Following e-mail conversations with the Planning Officer, Liz Arnold, we have revised our plans for the proposed extension of 15 St Lawrence Drive, HA5 2RL.

FRONT ELEVATION PROPOSED

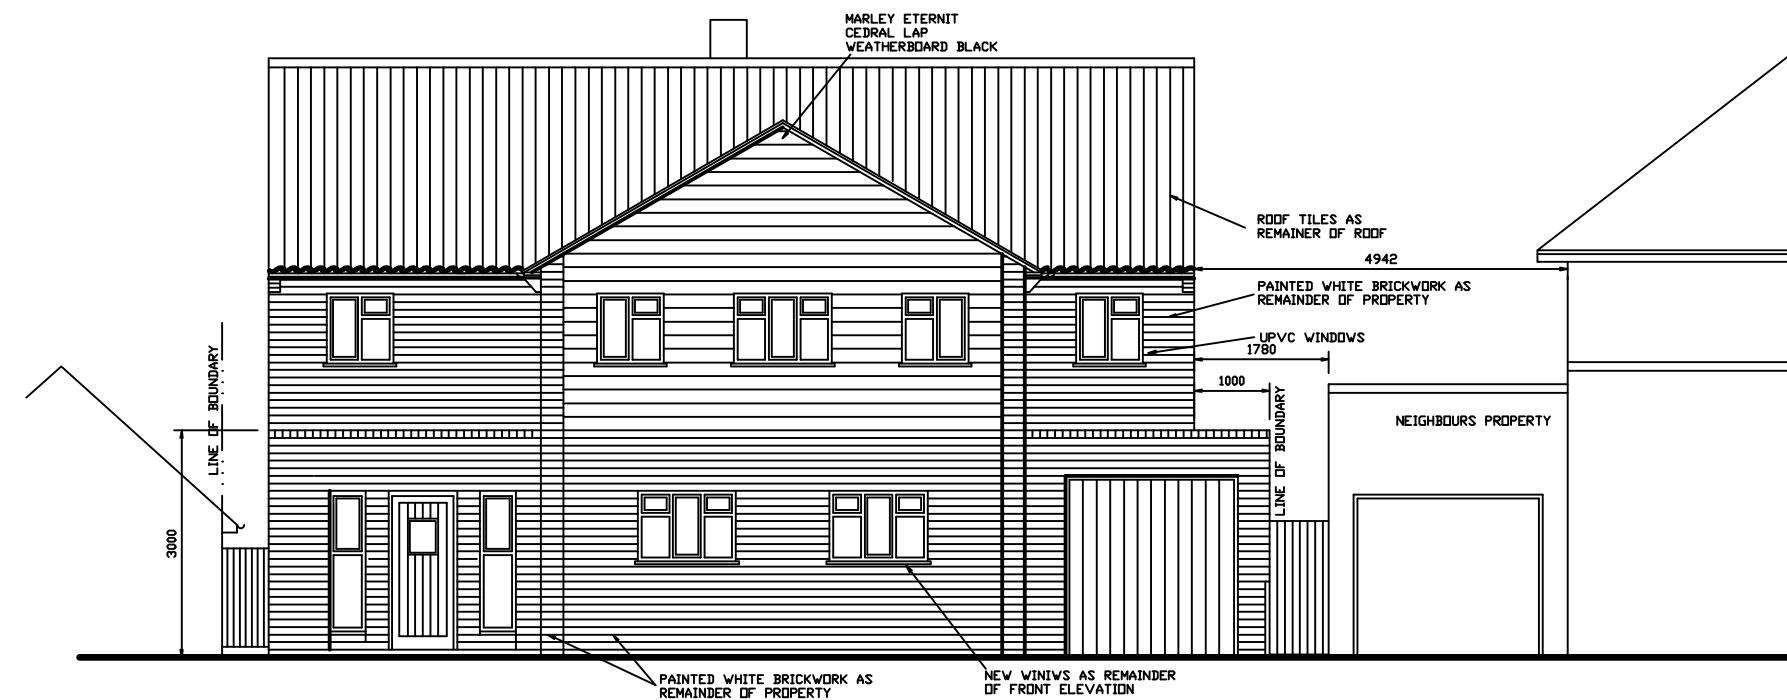
Taking into account the property is very simple and modest in design the introduction of timber on the gable end should reflect such character. This could be explored through either horizontal or vertical cladding. It is also suggested that the timber clad/ boarded area covers the first floor and roof eaves of the projecting gable.

In the revised plans, similar brick detailing has been added at each side of the front elevation. These brick 'piers' provide a border for the timber, or other cladding, of the first-floor and eaves of the gable end.

Use of a material such as MarleyEternit Cedral weatherboard is proposed as a more elegant, longer-lasting cladding than the timber which is often found on 1970's houses.

GROUND FLOOR PROPOSED

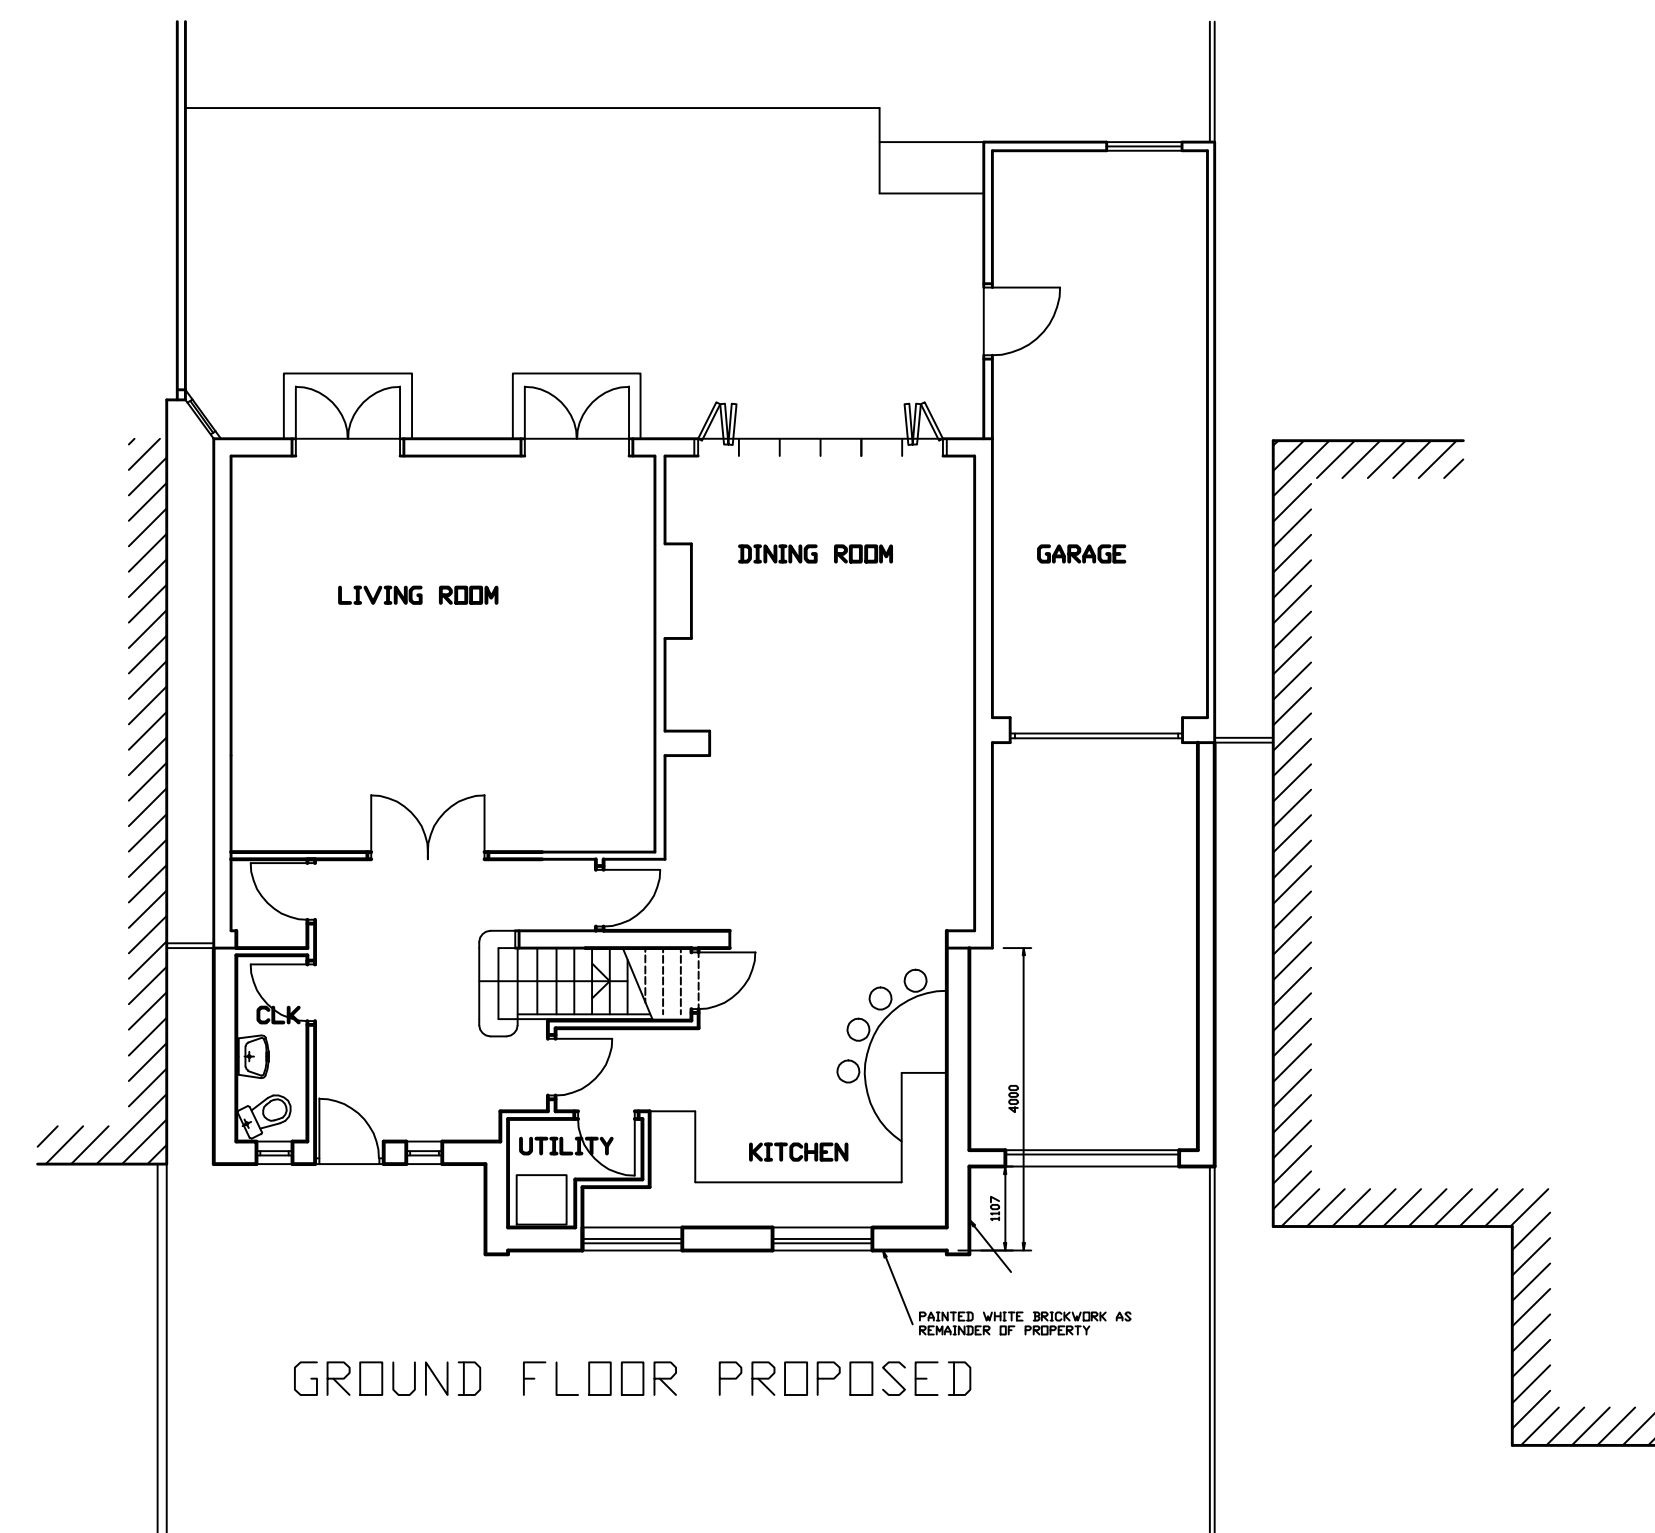
The front addition would need to be reduced to 4m in depth from the property's original front boundary line.

In light of the Council's comments, we have revised the plans and moved the front elevation of proposed extension so that its front wall is now 4 metres from the main front wall of the original building.

FIRST FLOOR PROPOSED

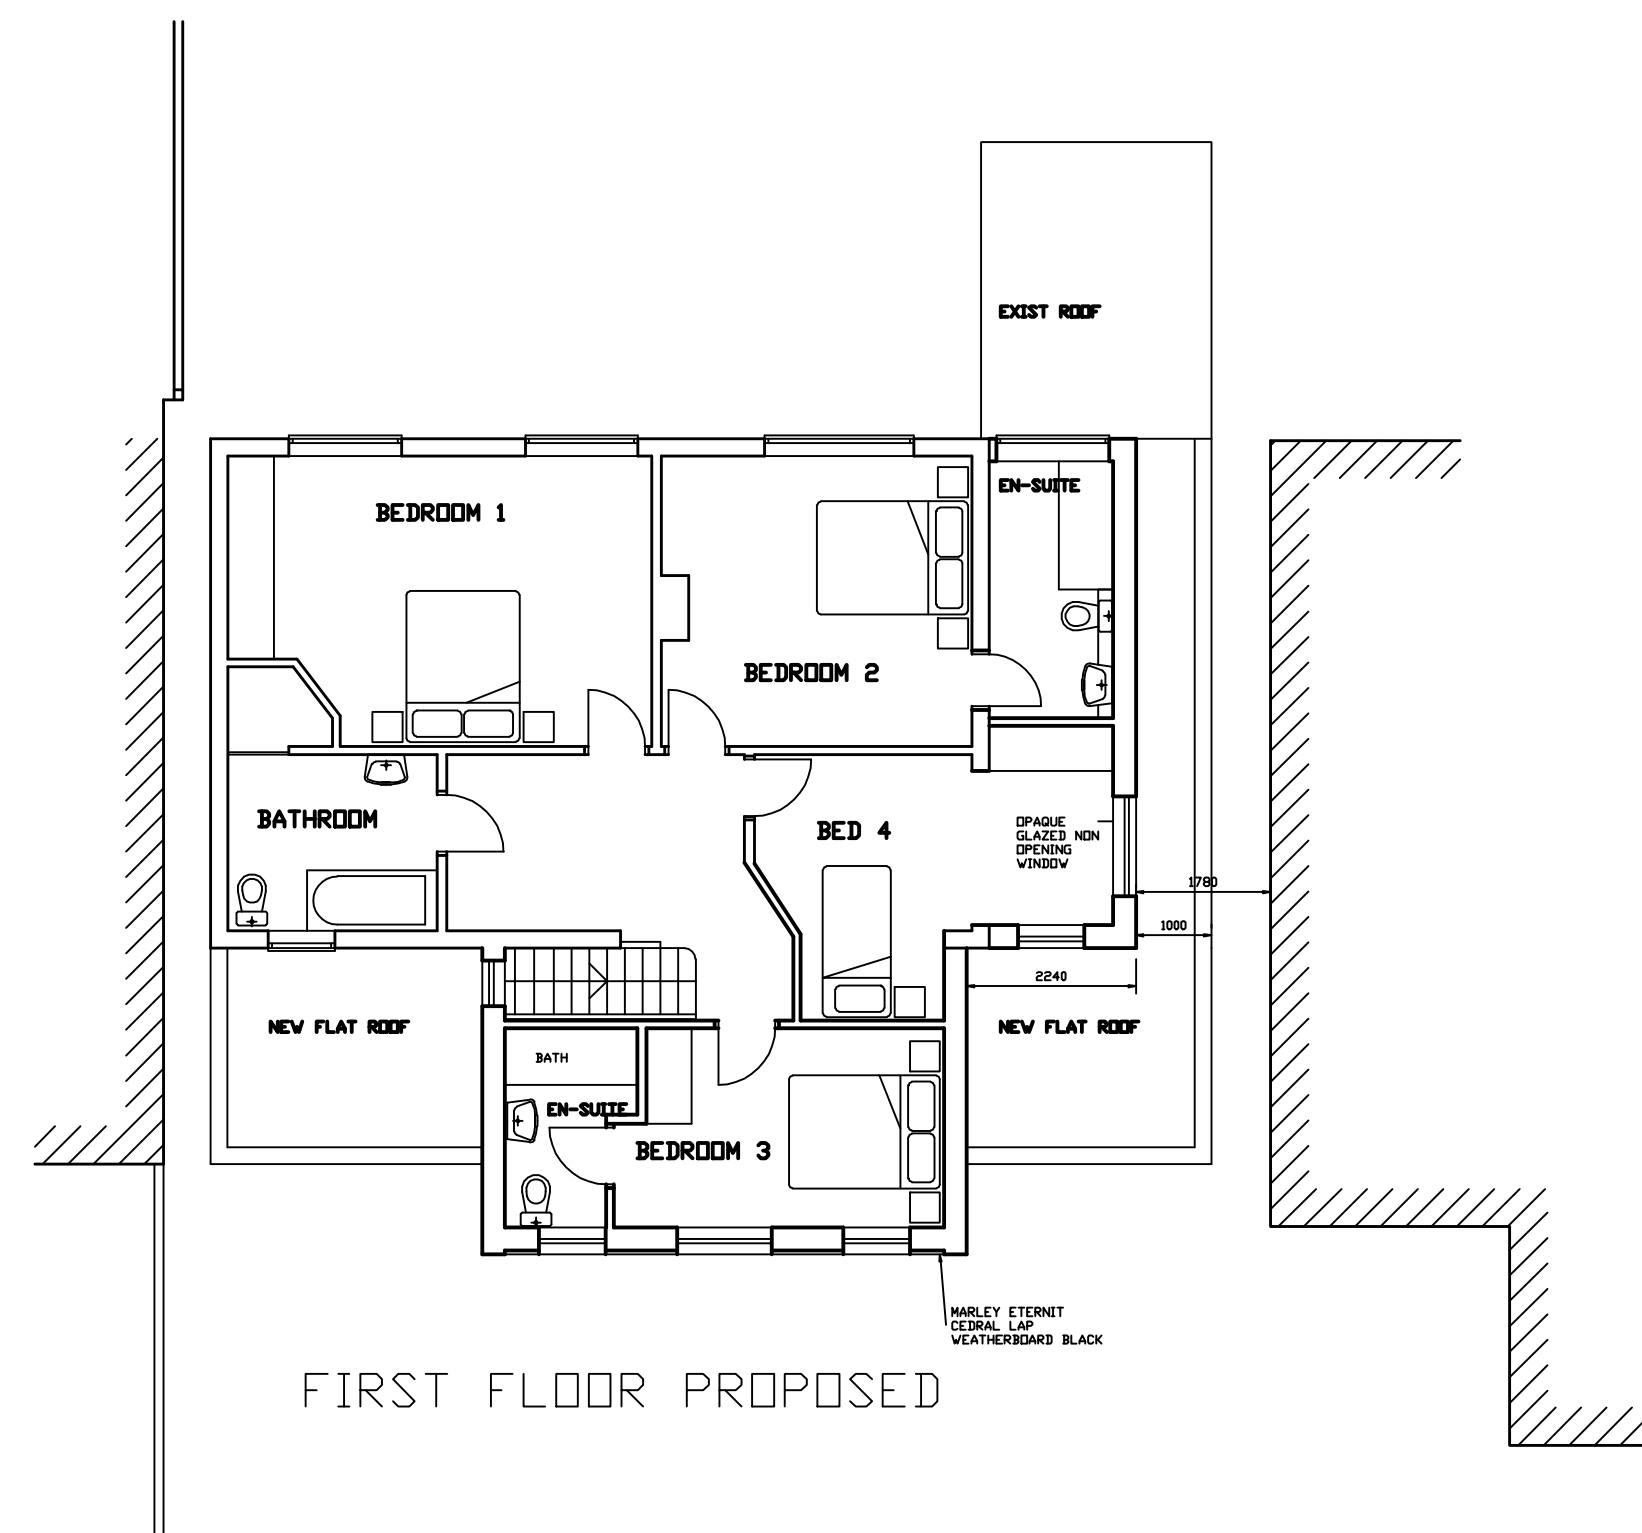
A 1.5m set in from the site's side boundary would be required particularly at first floor.

However, in response to the Council's request, we have reduced the width of the side extension by some 0.4m, which increases the spacing from the adjacent house to more than 4.9m at the first-floor level.

Reducing the width of the side extension further to achieve a set-in of 1.5m from the site boundary would not produce a worthwhile increase in living space. Furthermore, it would result in the extended building taking on a 'lop-sided' appearance, which the Council specifically requested that we avoid.
